**Consultation Response from KC,
Highways Development Management**

**2024/91760 Land adj Healey Junior Infants and Nursery School, Healey lane, Healey, Batley,
WF17 8BN**

**Erection of 19 dwellinghouses with associated car parking, landscaping and boundary
treatment and other associated associated works**

Date Responded: 21/10/2024

ROAD 1 PROFILE
SCALE: 1:250 HORZ., 1:50 VERT.
(5 x VERT SCALE)

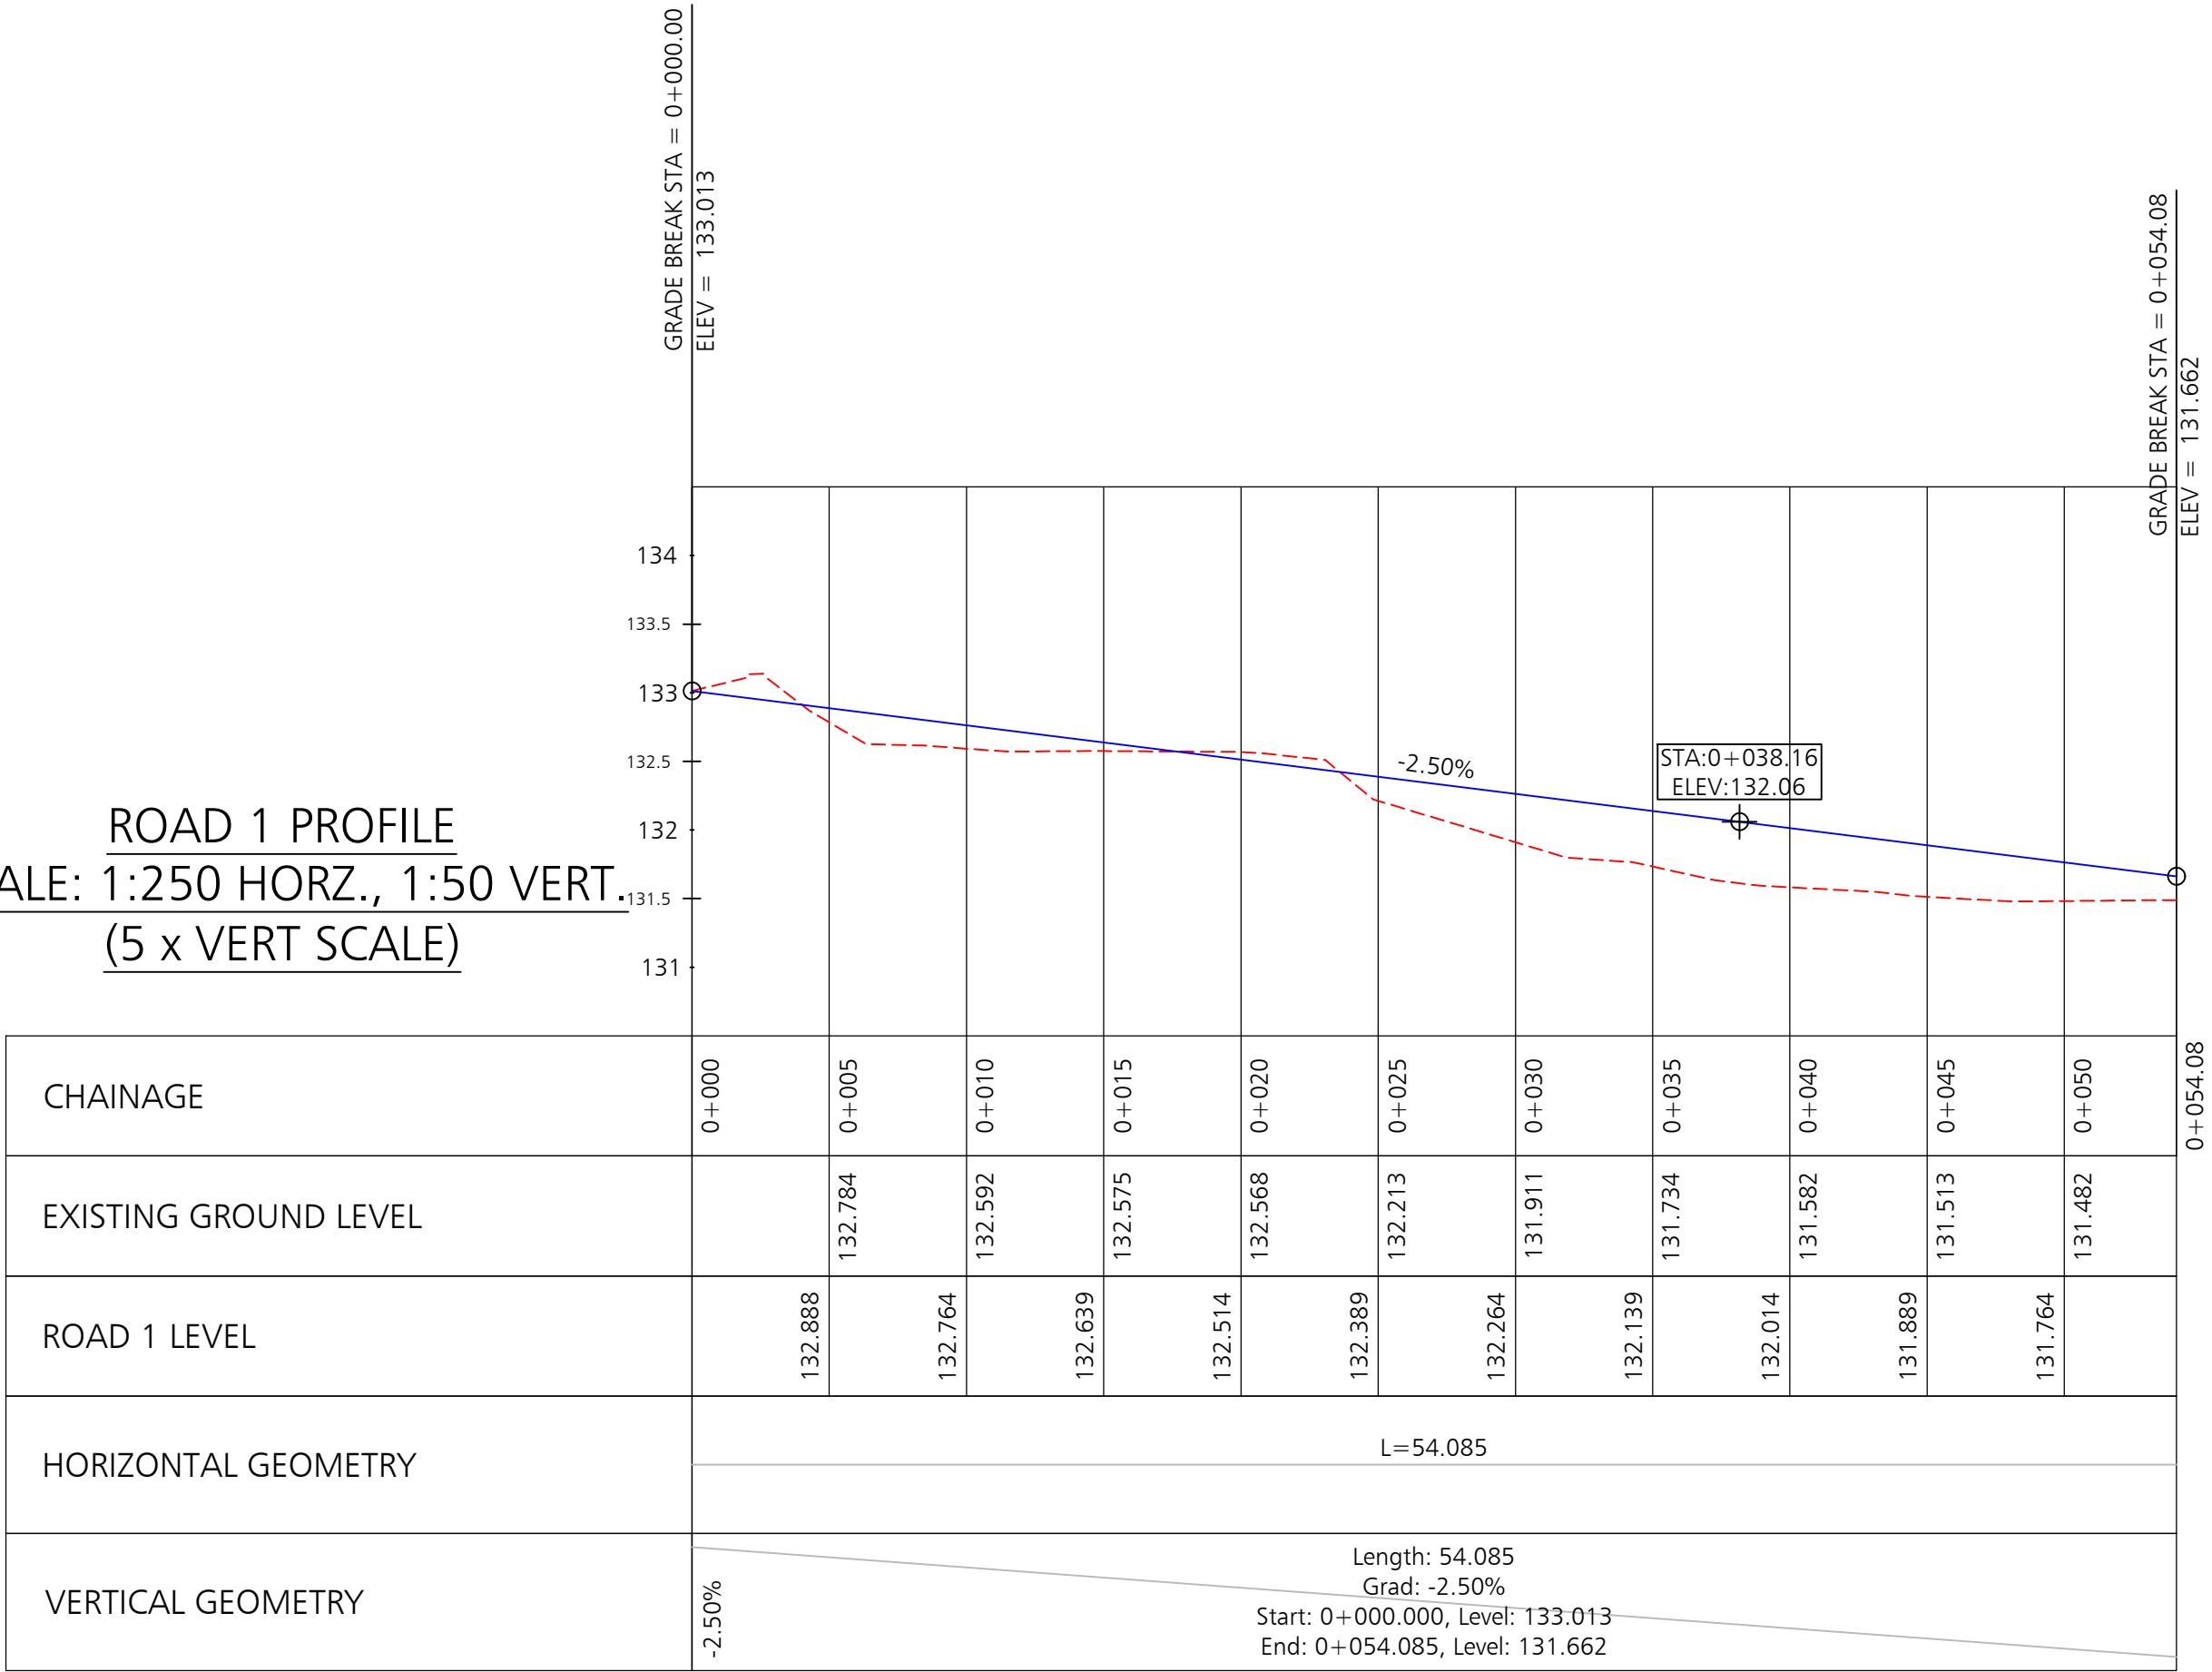
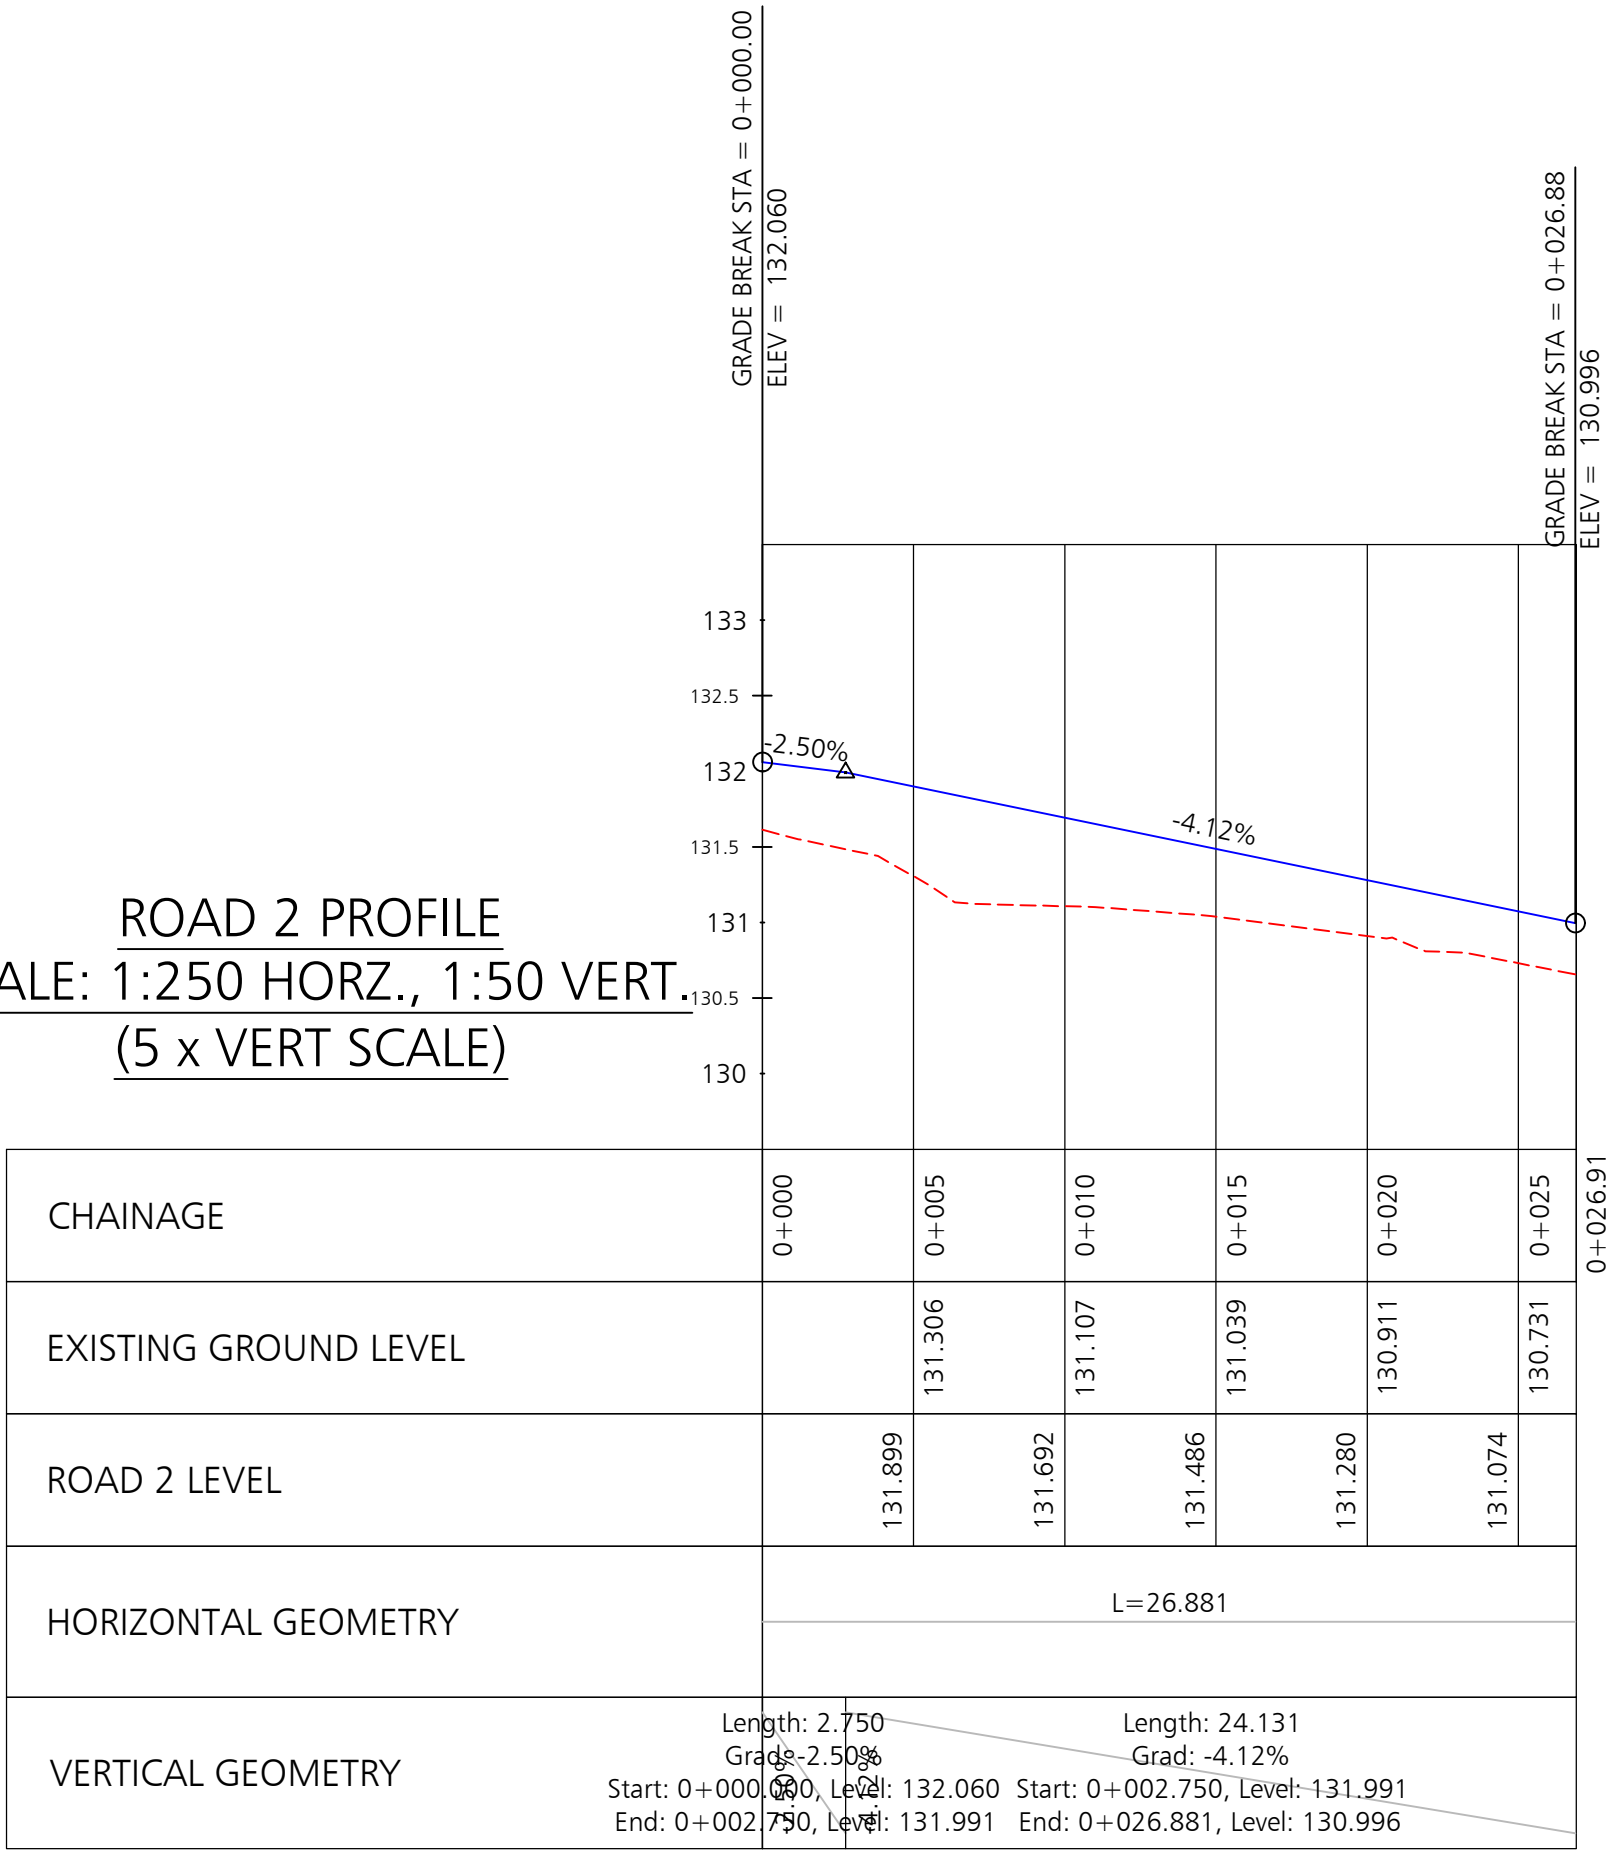
A long section has not been provided and will be required to ensure compliance with the Equalities Act 2010 where necessary. This must include details of the vertical alignment to determine appropriate carriageway and footway gradients. Shared surface carriageways will need to be Equalities Act 2010 (DDA) and Kirklees Design Guide compliant and be no steeper than a maximum of 1:21 or 5%. If the carriageway is steeper than 5% then a Local Residential Street (Type B) with footways both sides would be required as per Table 1.
